District ref: 6/2017/2964/MAJ

HCC ref: WH/4/2018

Blue Moon Paddock
Woodfield Lane
Brookmans Park

Proposal

**Drawing No.**  
**P/502/A**

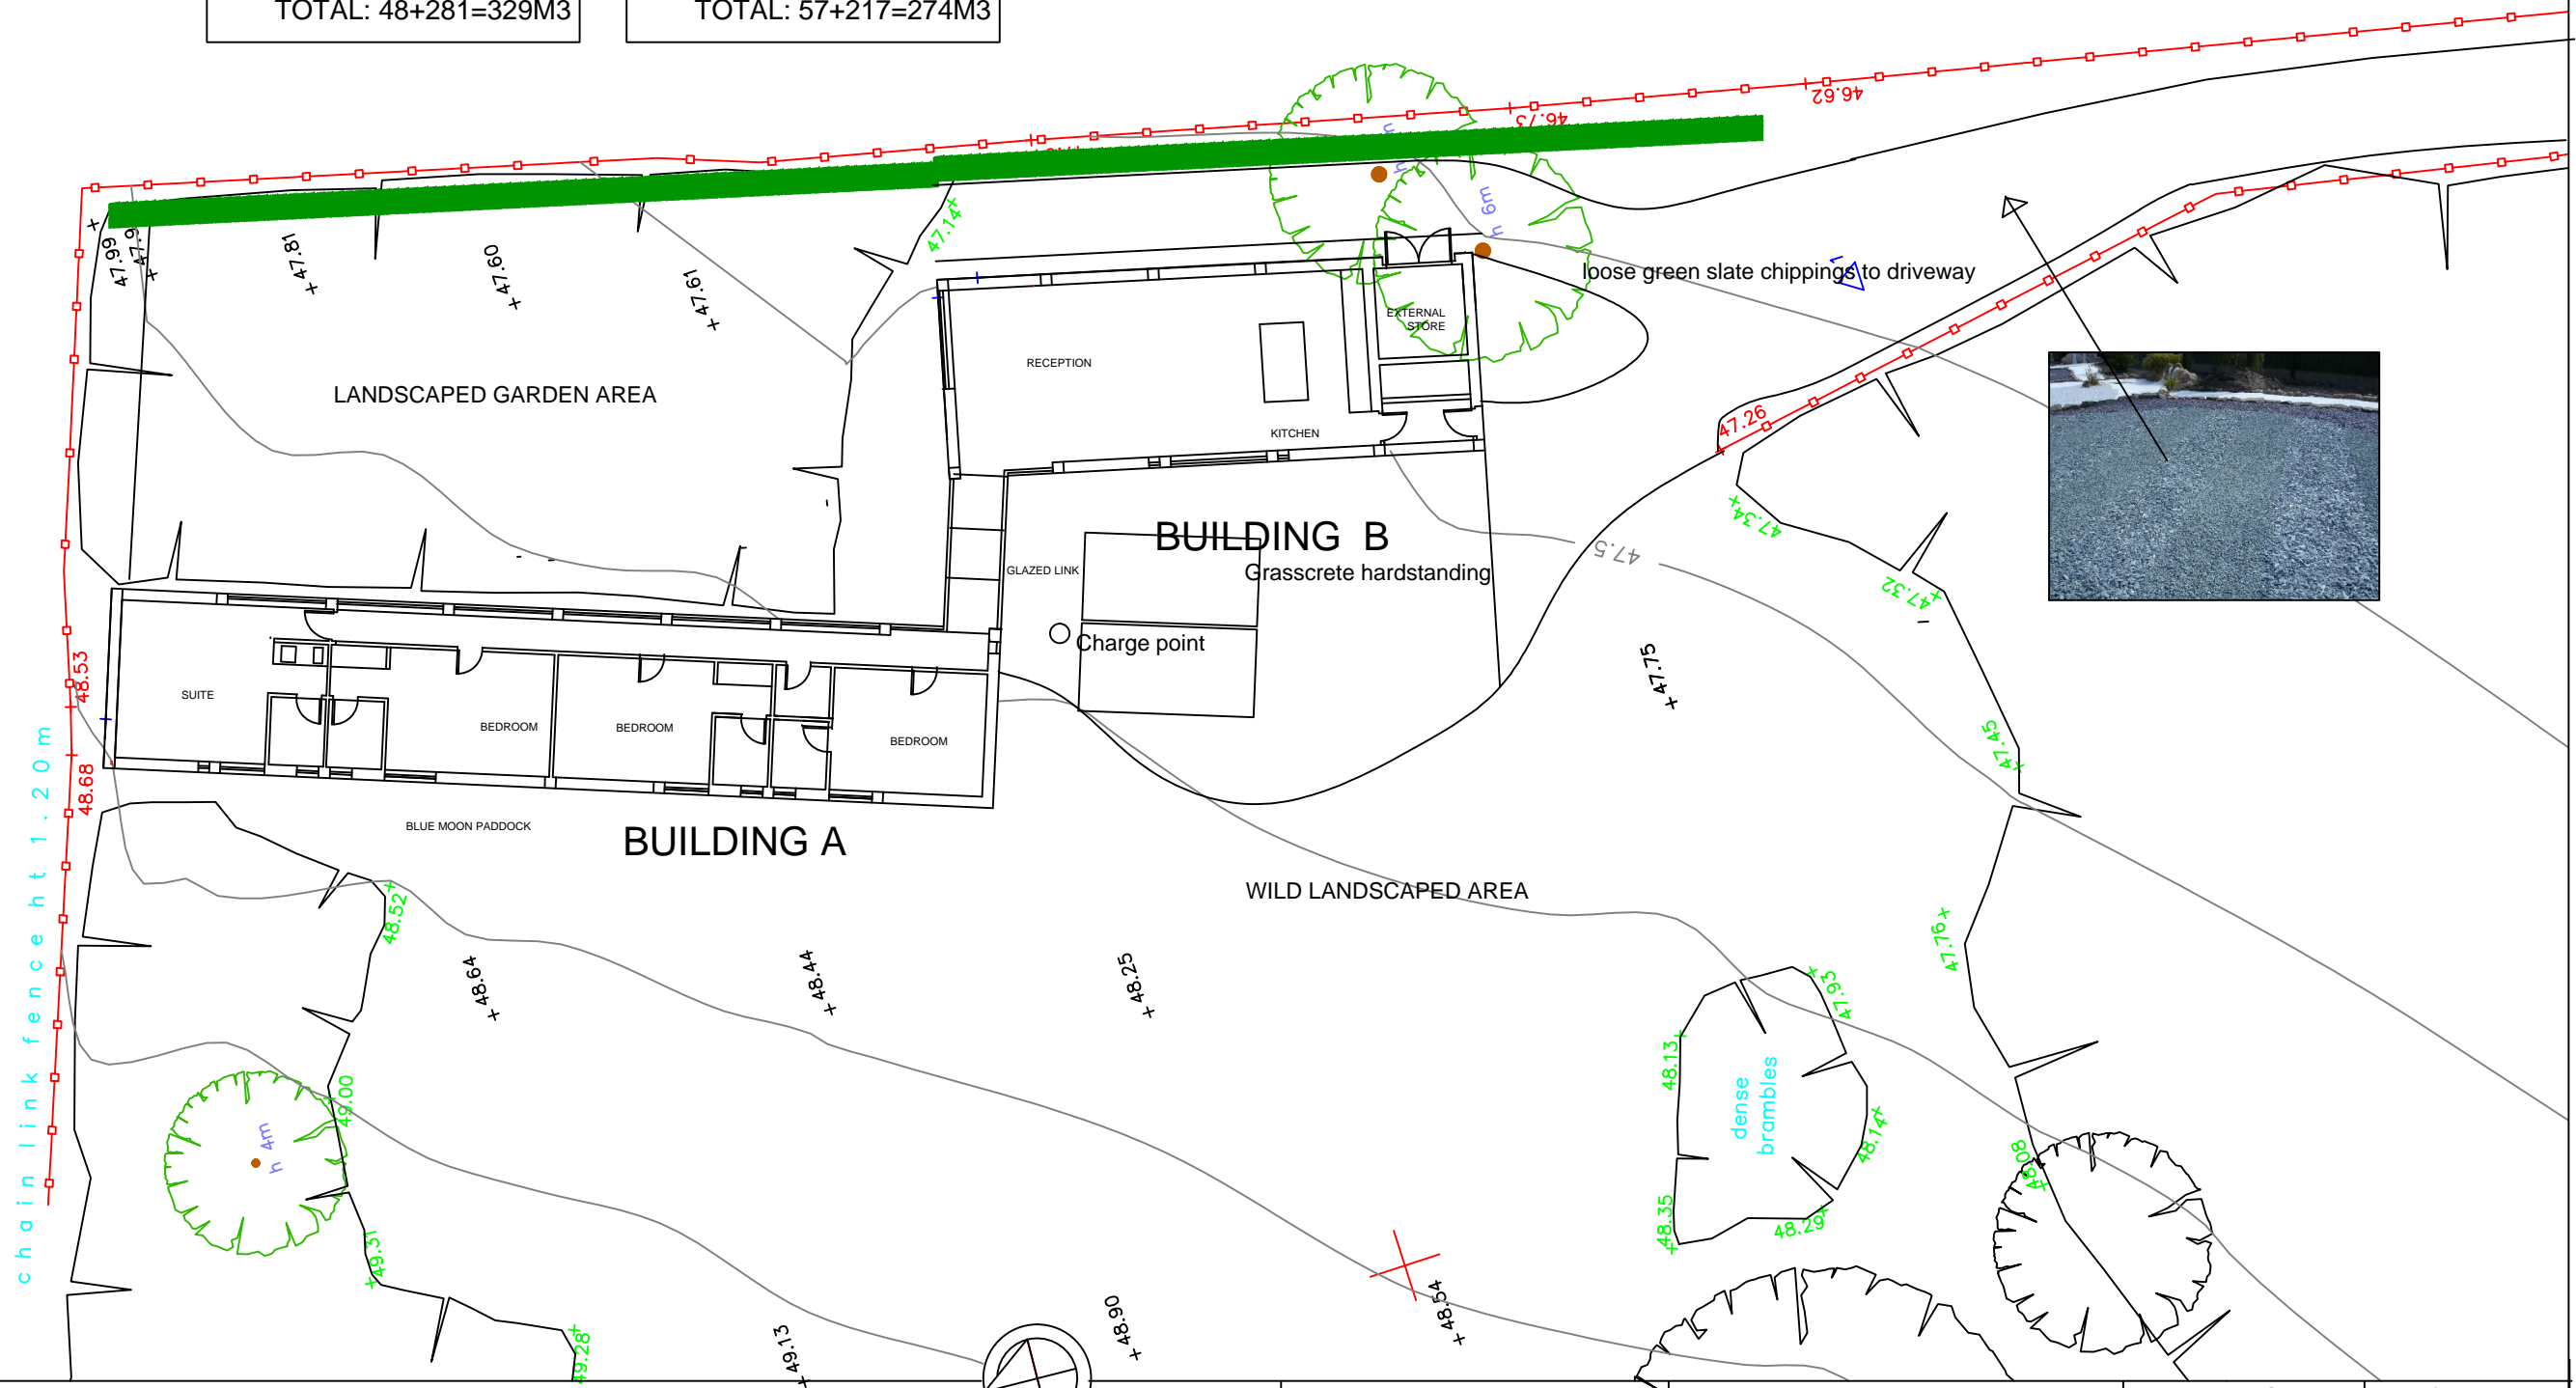
The site is served by a new 65 meter driveway with gates set over 6 meters from the highway allowing vehicles to fully pull off from the road and reduce opportunity's for obstruction

Location of refuse bins is unclear, but they could potentially be stored within safe carry limits.

The site has a large parking area. Some aspects of the proposal suggest the site may be used for non-residential activities such as tourism/events, the LPA would be recommended to use this opportunity to review the adequacy of provision of parking

It is recommended that the LPA consult the appropriate fire authority regarding access and distances to the property including maneuvering dimensions.

Cycle storage is not specifically noted in the proposal, but no aspects of the design prevent the use of sustainable modes of transport such as walking or cycling.
